R/191/21/L

We sent you safe versions of your files; Existing Plans A3.pdf; Hobbs Farmhouse Proposed Plans A3.pdf

R/191/21/HH

R/192/21/L

Drawing: Proposed Elevations

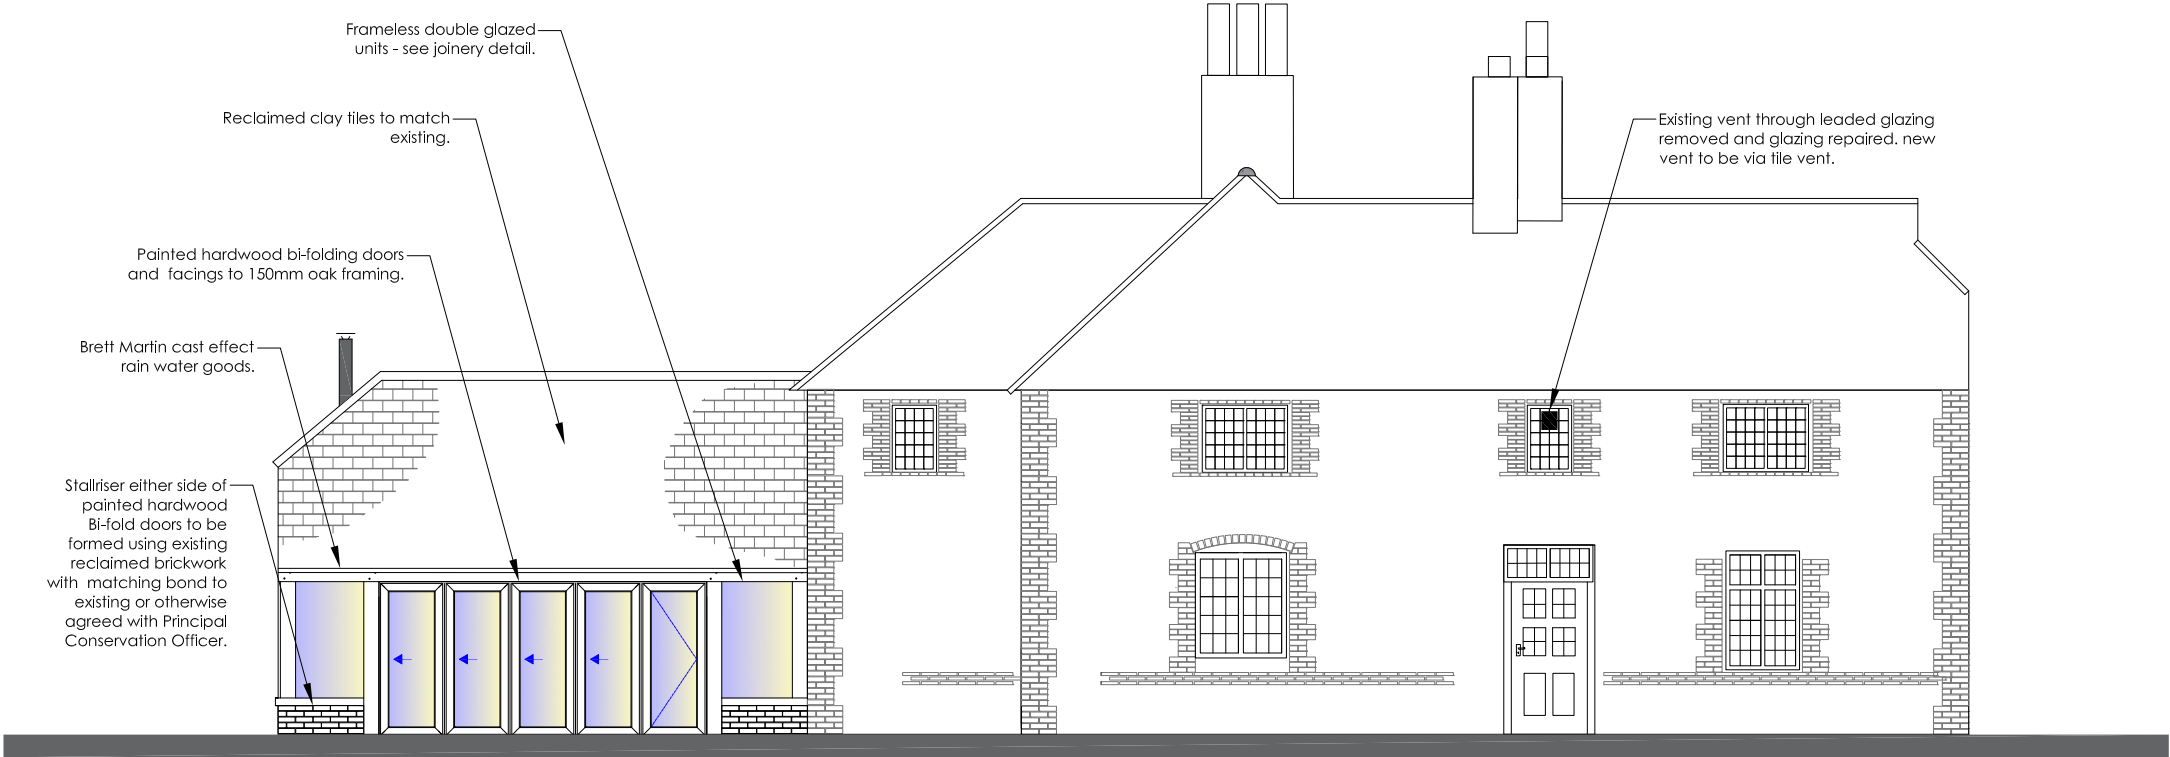
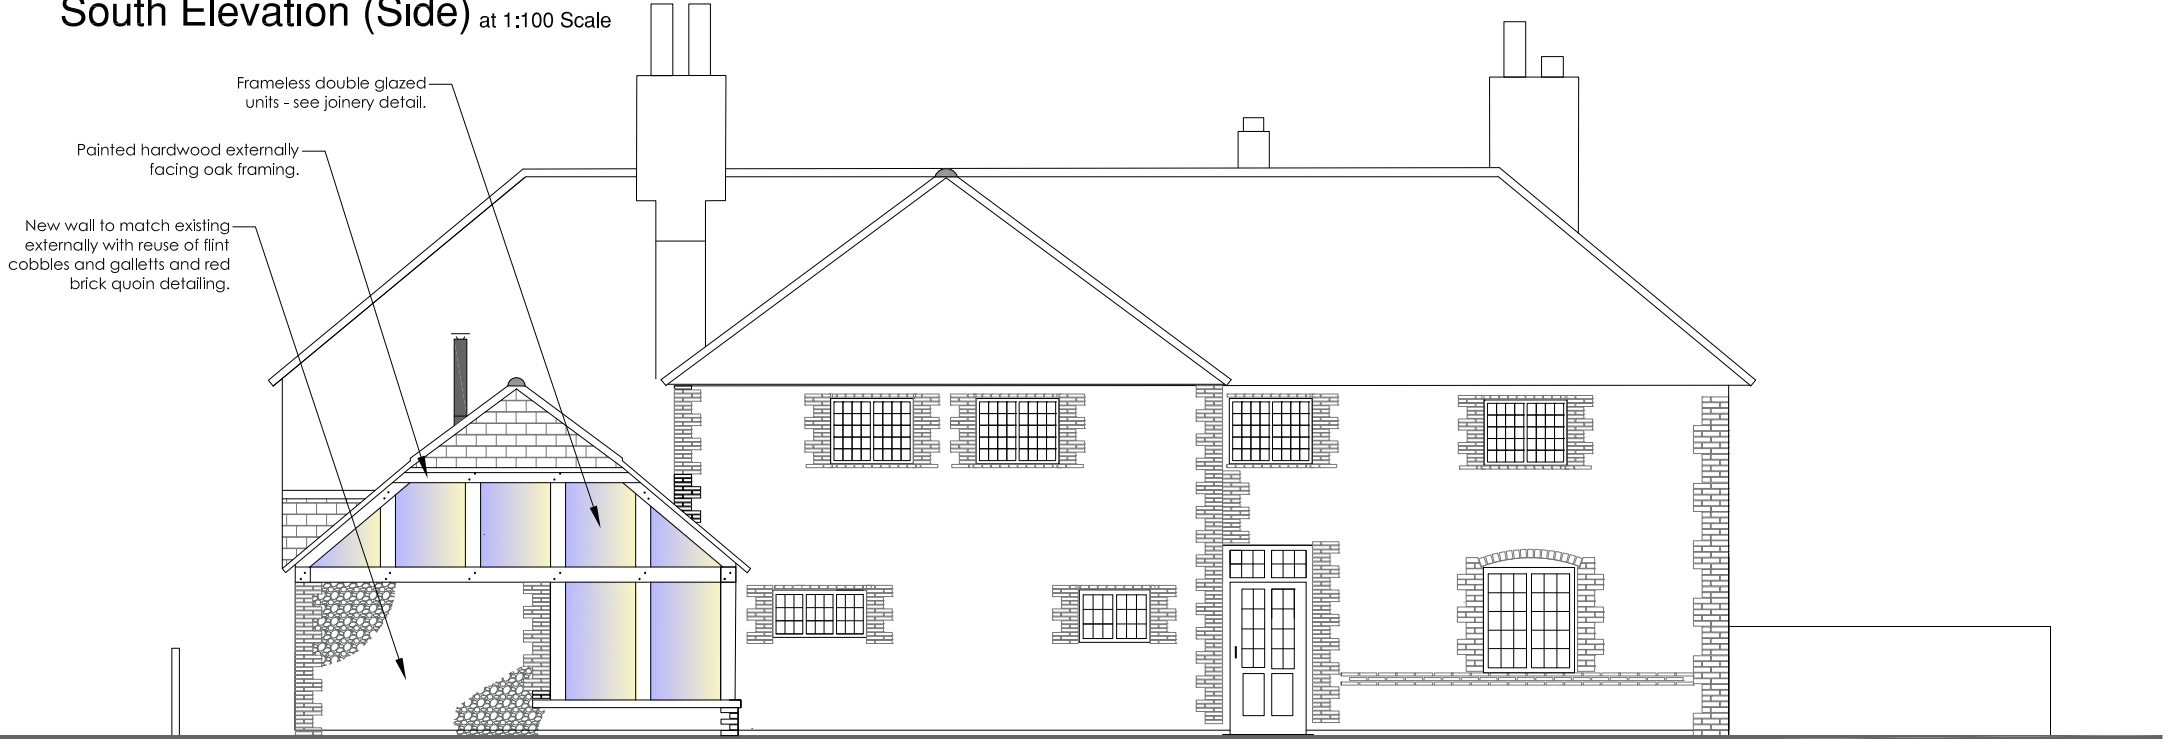
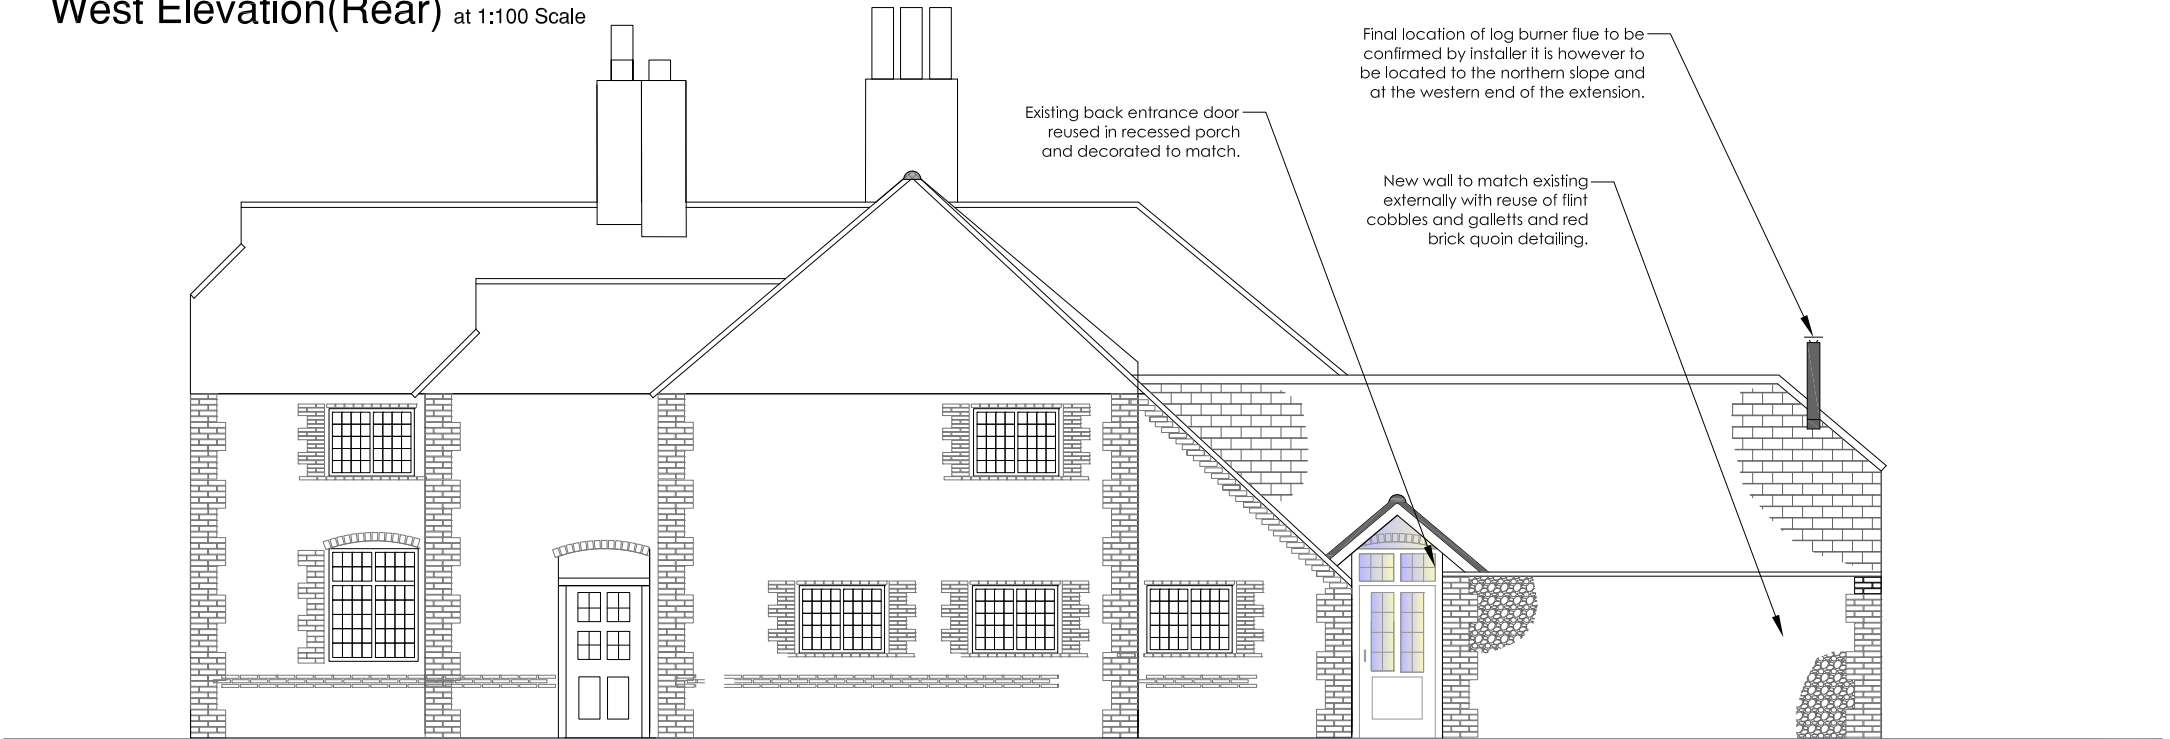
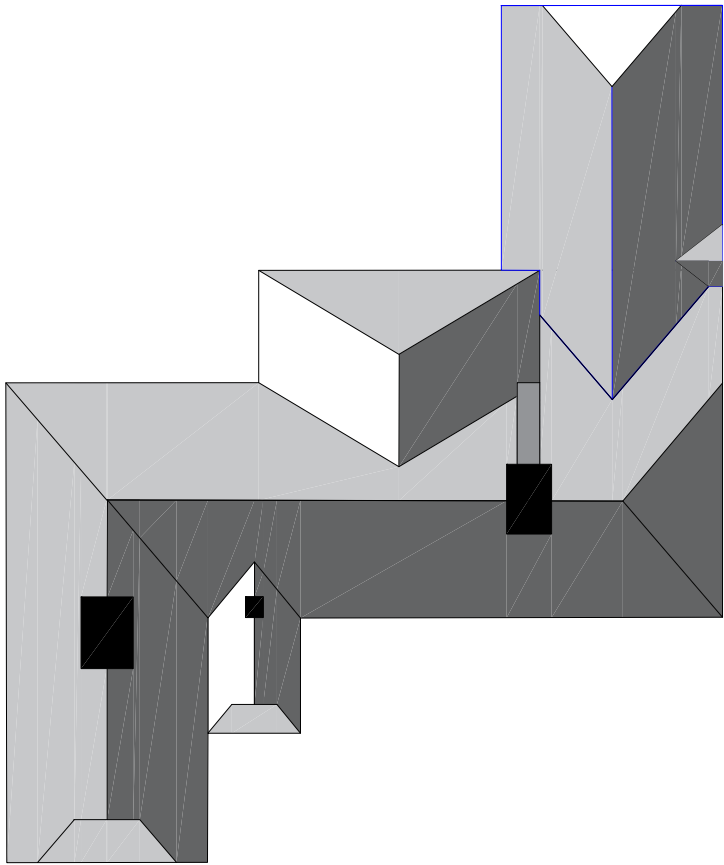
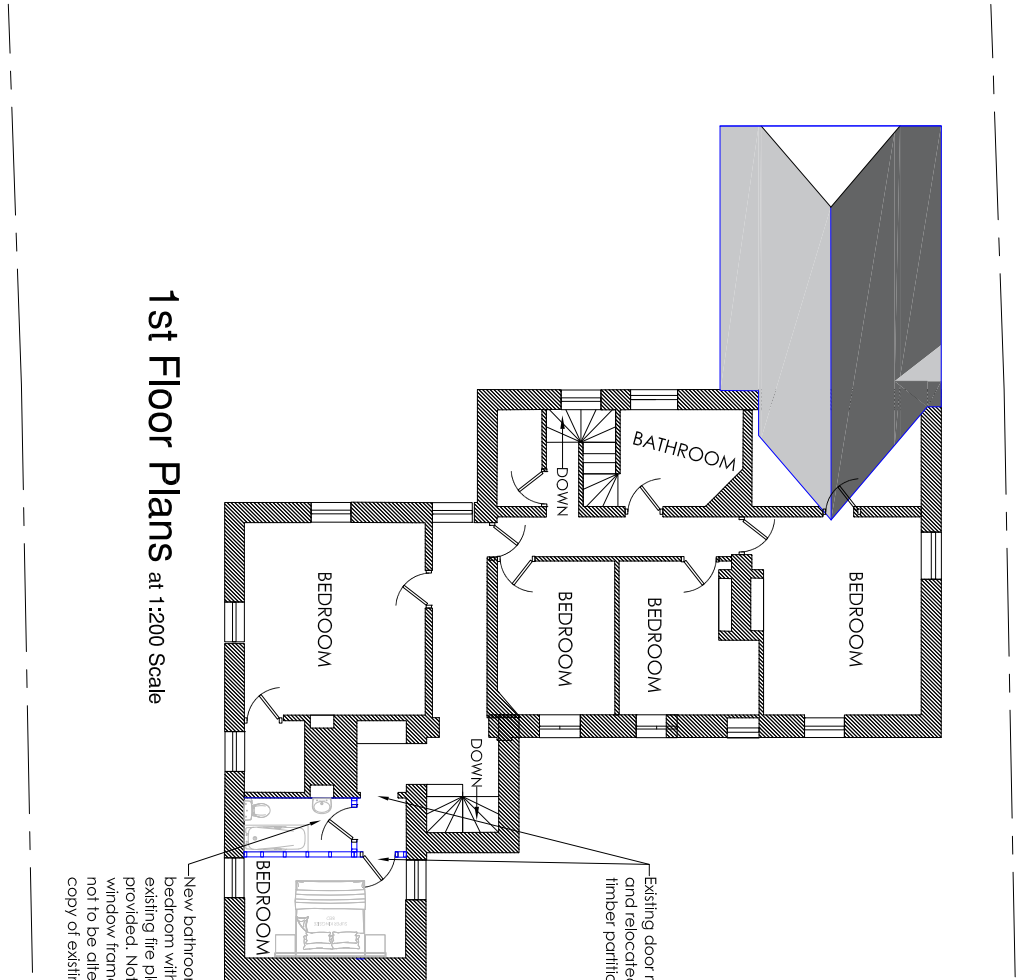
The proposed south (side) elevation is inconsistent with the proposed ground and first floor plan. Please review and amend.

The windows on the proposed south (side) elevation are inconsistent with the proposed first floor plan. Please review and amend.

The proposed south (side) elevation is inconsistent with the proposed ground and first floor plan. Please review and amend.

As per our discussion, just the first floor plan and relates to the above.

As per our discussion as above.

As per our discussion as above.
